**FINAL DRAINAGE REPORT FOR
HOMESTEAD AT STERLING RANCH
FILING NO. 2**

Engineering Review

Project #09-007
SF -19-004

**LOTS 13-18 STORM SEWER (PRIVATE)**  
SCALE 1"=30'

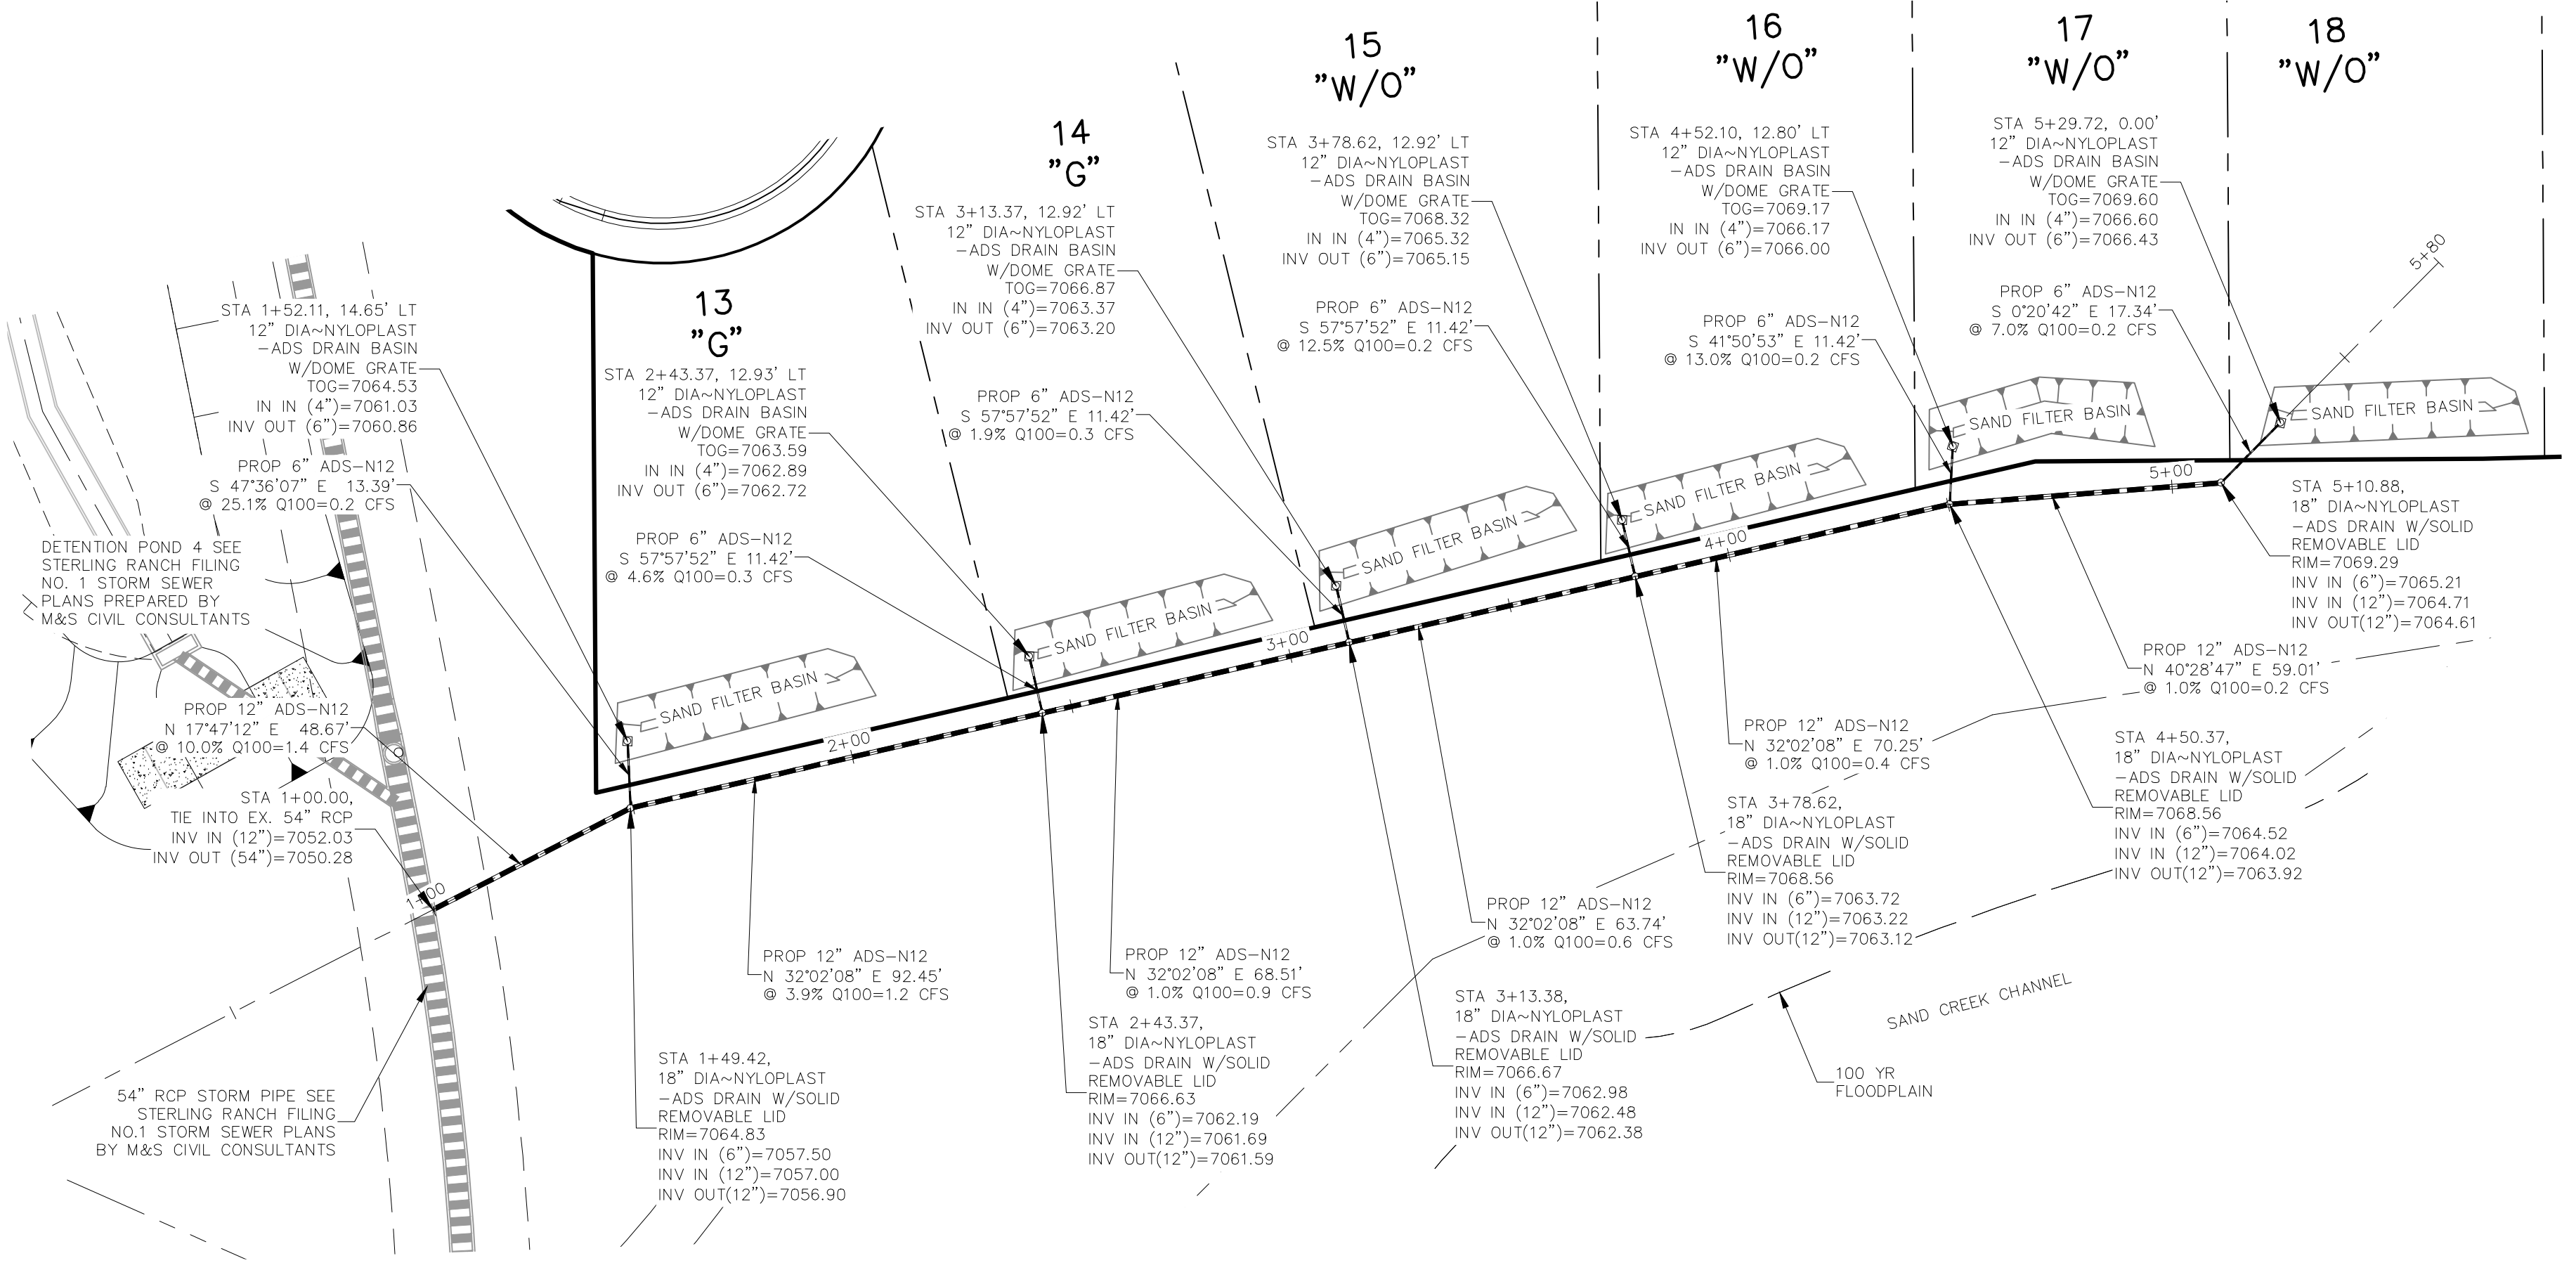
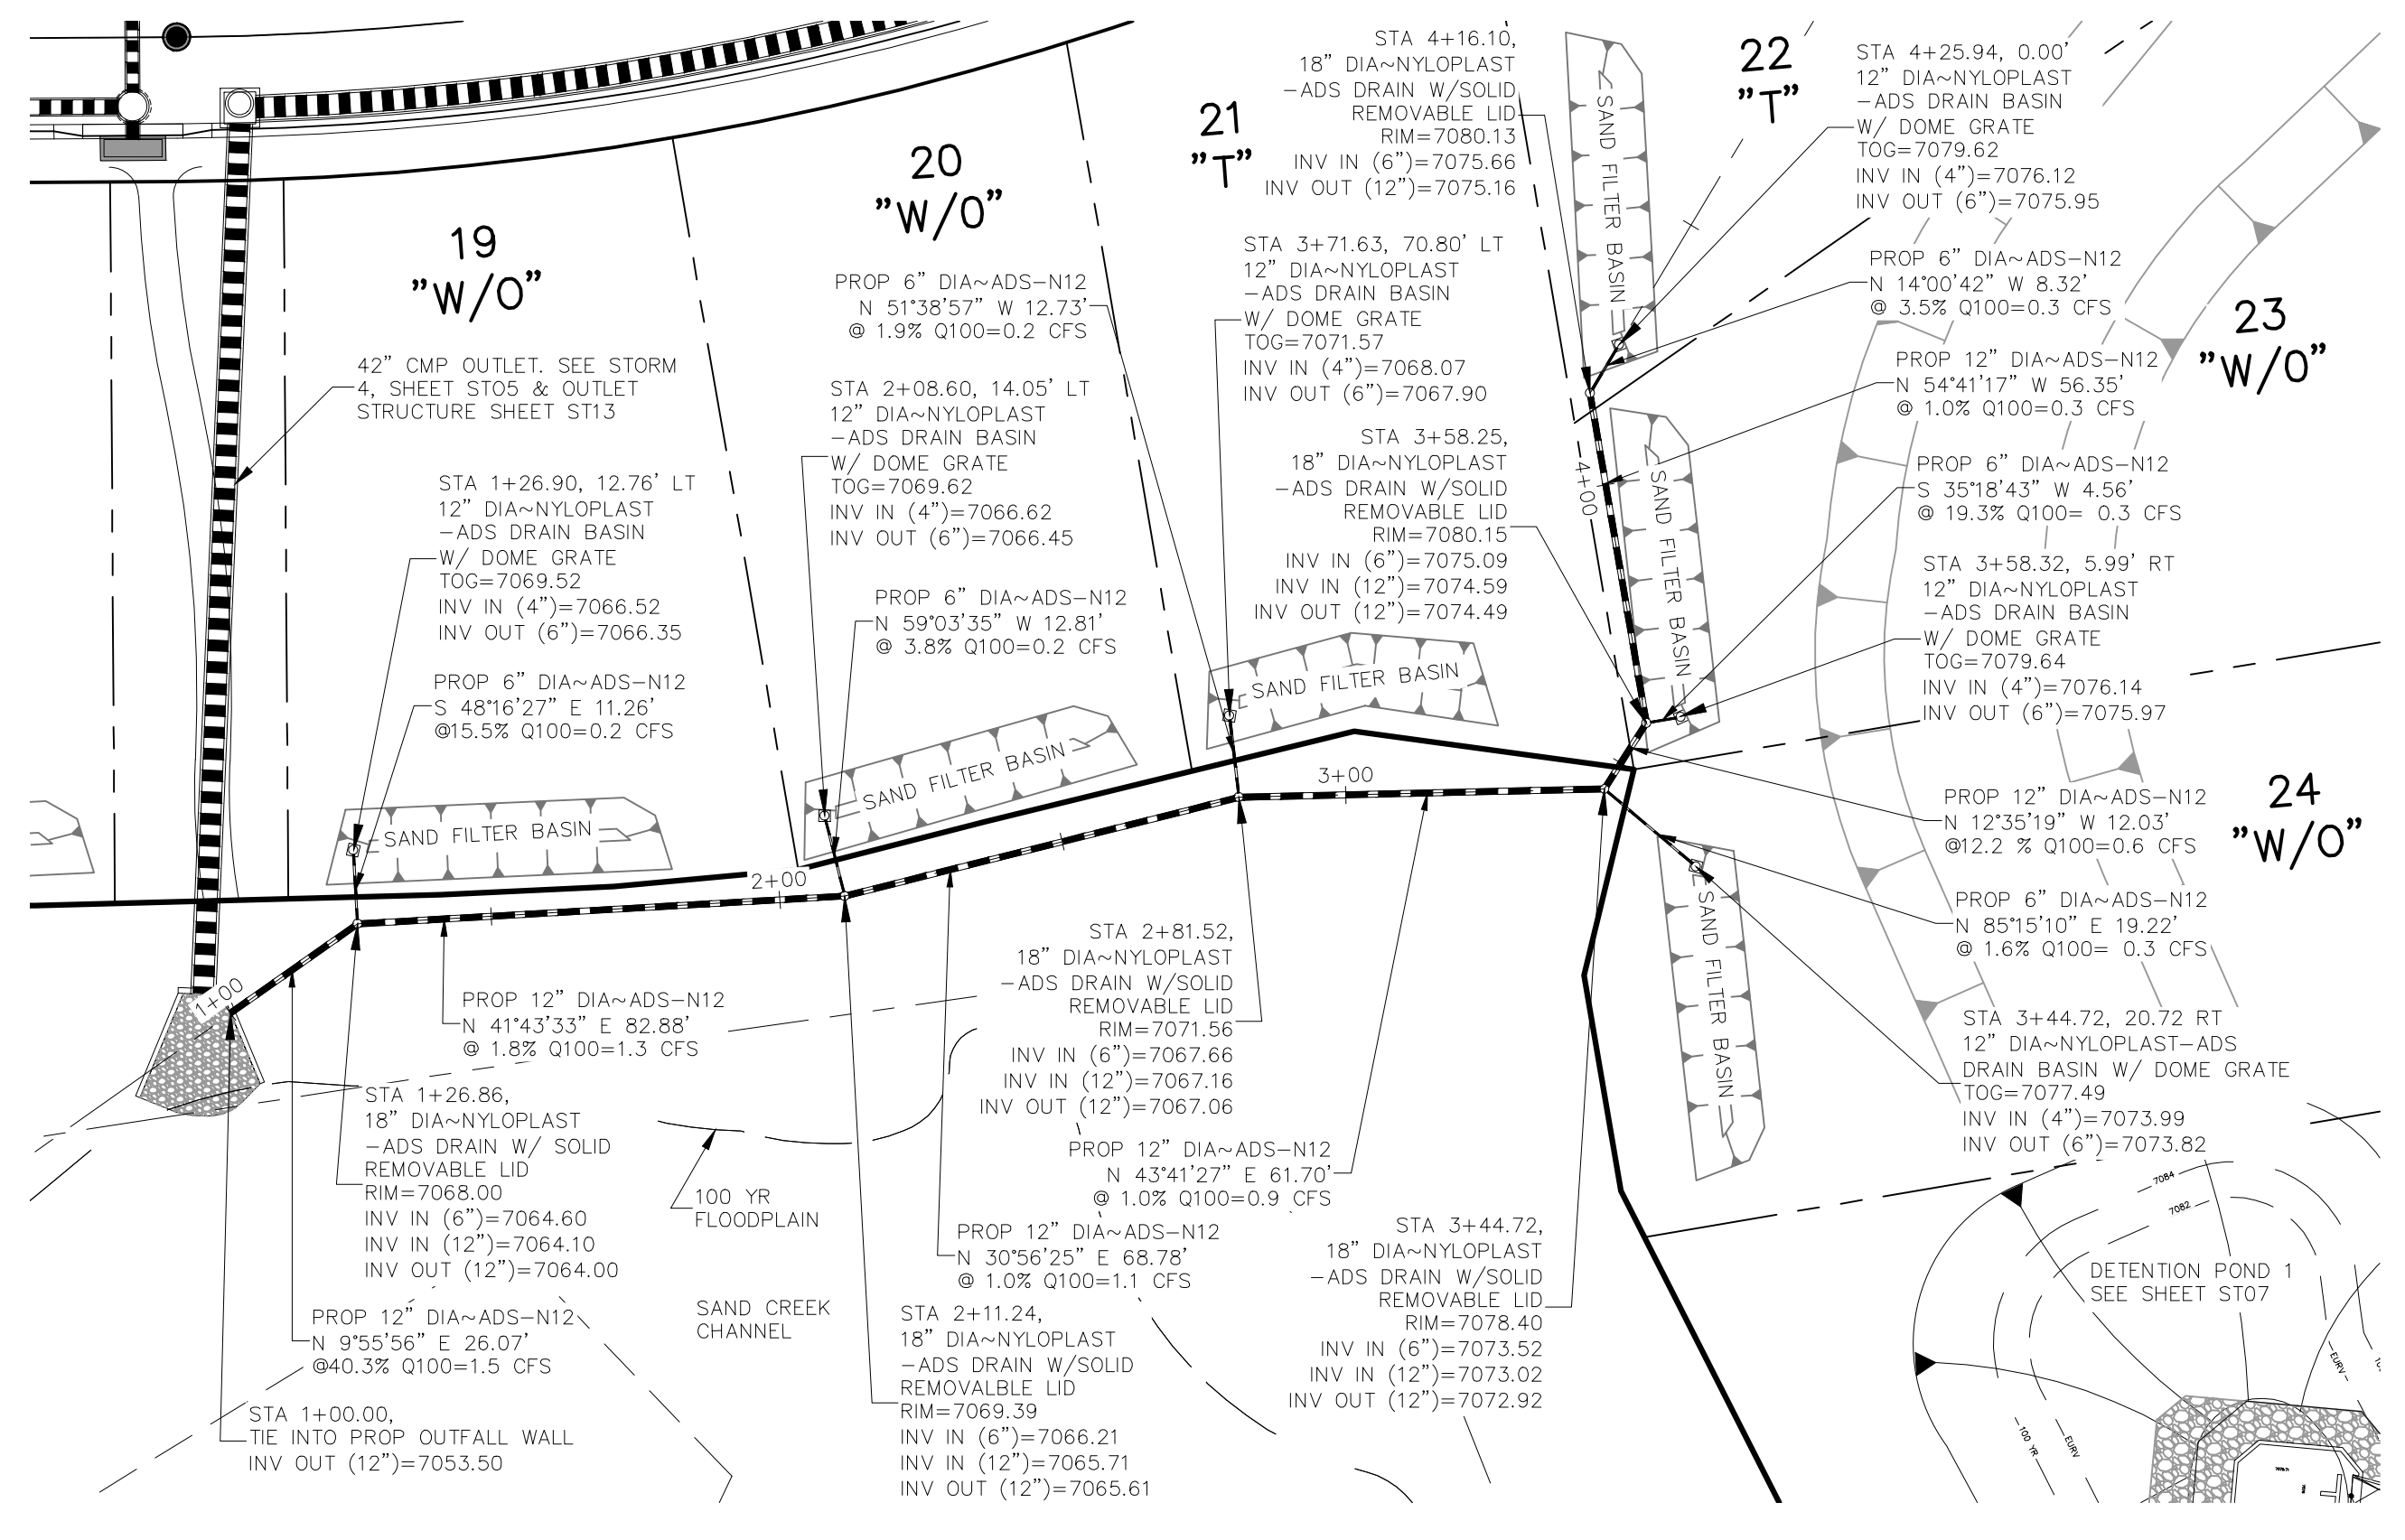
Indicate where the access to these individual SFB's will be provided. etc.
